Planning Application: 3/2024/0494

**Approval of details reserved by condition 10 (historic building record) of
planning permission 3/2023/0814.**

Springwood, Whalley Road, Hurst Green

Plate 2. 25-Inch OS Map of 1894 (National Library of Scotland, 2024)

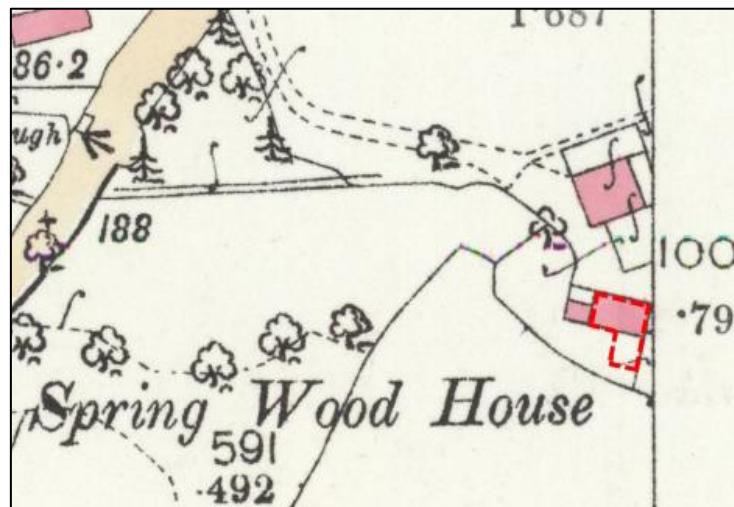
2.1.2 – This paragraph contradicts the statement made in 2.1.1 "the Barn is thought to date to the very late 18th to early 19th century gleaned from historic maps". The earliest available map that is not that which is shown in Plate 2, dated 1894, as the barn is clearly shown on the 1st Edition 1:10560 Ordnance Survey, Lancashire Sheet 54, surveyed 1844. Other earlier County-wide mapping (1786-1828) is not of an accuracy to be able to determine the presence of individual buildings but demonstrates buildings in the area. All of these maps can be viewed on the National Library of Scotland website.
